Our ref: OUT22/11047

Subject: **Oakdale East Industrial Estate (SSD-37486043) – Environmental Impact Statement (EIS)**

Detailed advice to DPE Planning & Assessment regarding the Oakdale East Industrial Estate (SSD-37486043)

Figure 2-4.
Watercourses

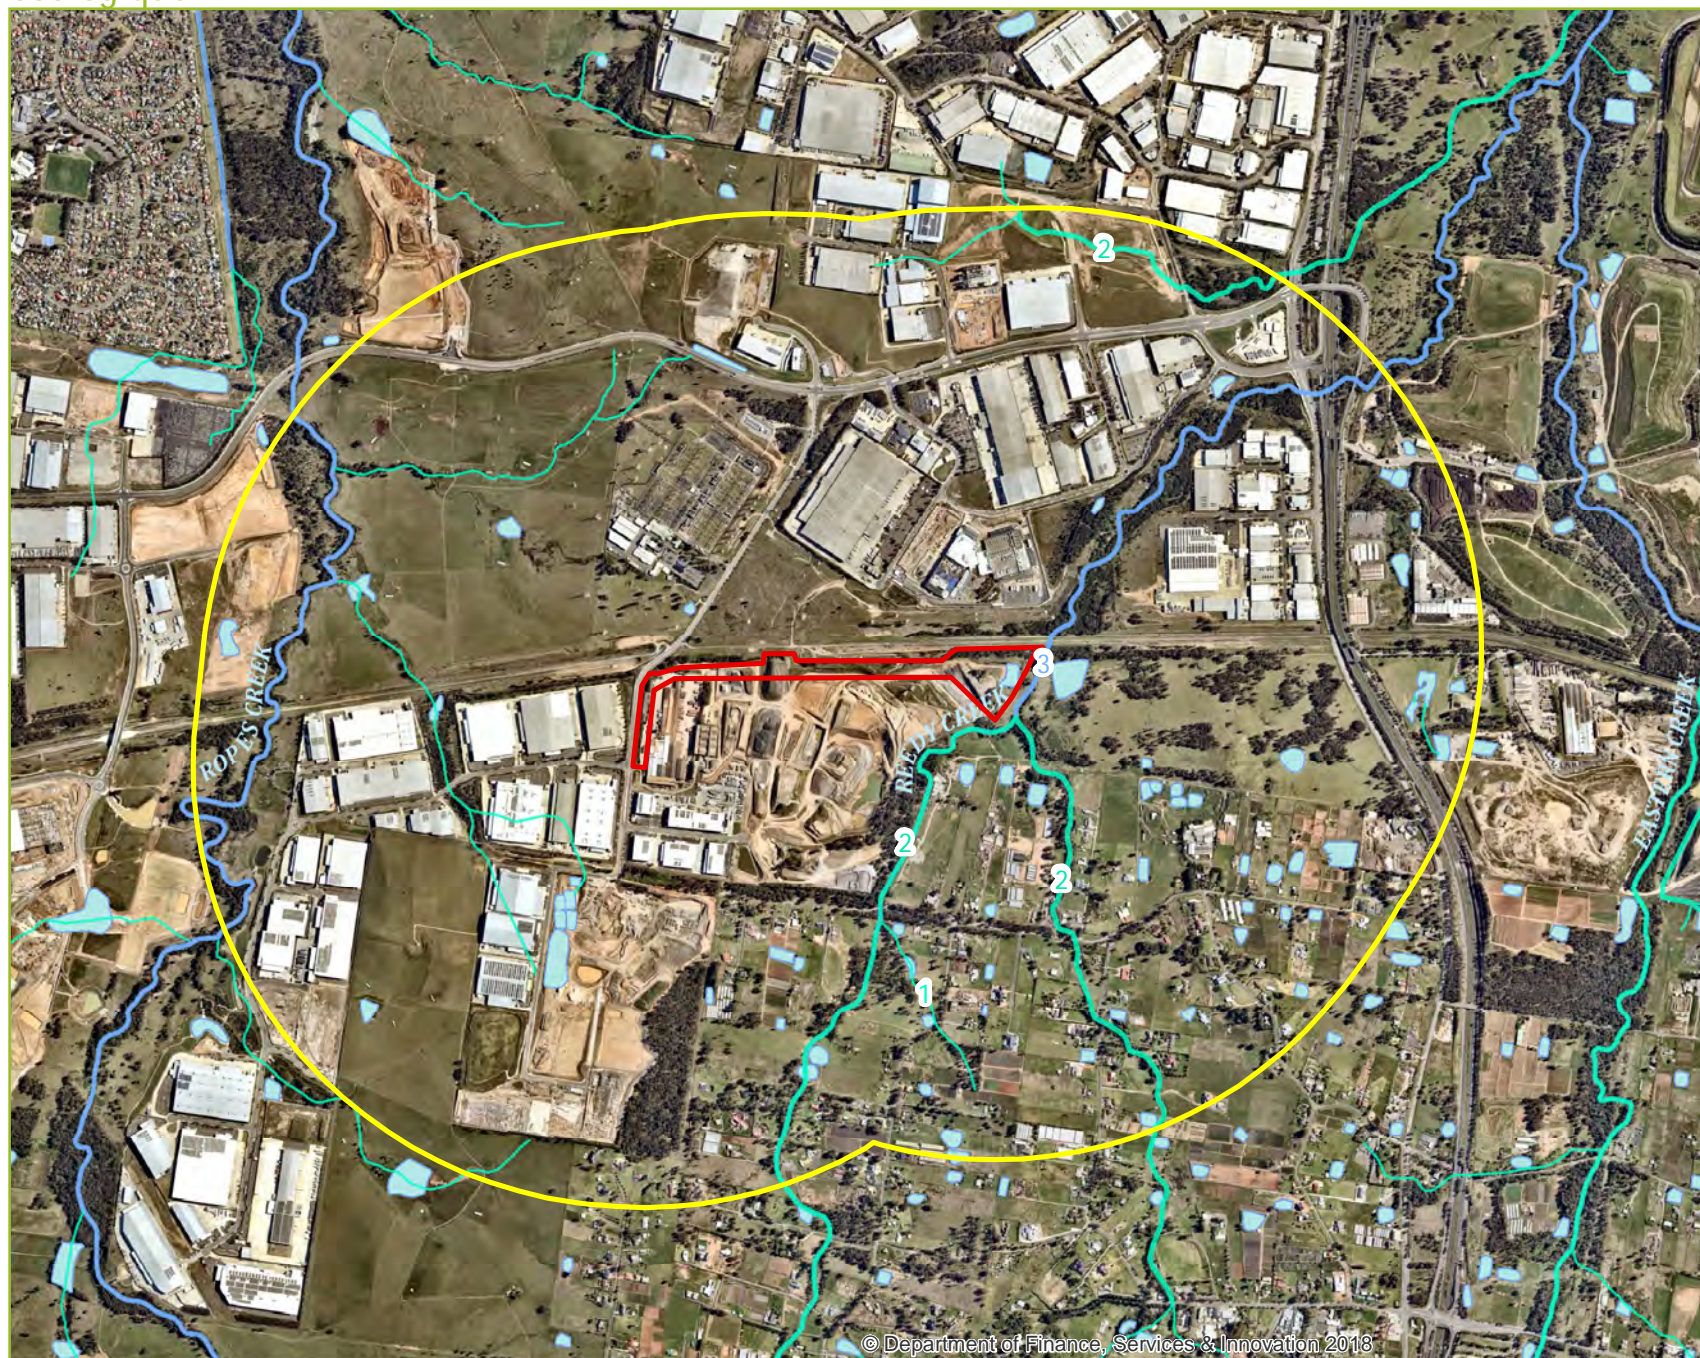
Reedy Creek runs the eastern boundary of the site. The creek enters the site as a 2nd order stream in the south-east corner, and becomes a 3rd order for approximately 250m of the north-eastern corner of the site. There are a few stormwater and basin outlets proposed into Reedy Creek, these should show due consideration to the Guidelines for Controlled Activities.

Works generally appear to be outside of waterfront land with the exception of a point in the middle of the eastern boundary and the south eastern corner. Even in these locations, works generally appear to be outside of the inner riparian zone (10m) with encroachments into the outer riparian zone. It is noted that the extent of earthworks in forming building pads was approved under DA347.1/2021. A vegetation management plan will be required post approval.

Ensure works within waterfront land are in accordance with the Guidelines for Controlled Activities on Waterfront Land (NRAR 2018).

Prepare a Vegetation Management Plan for the site and include details of required setbacks and offsetting.
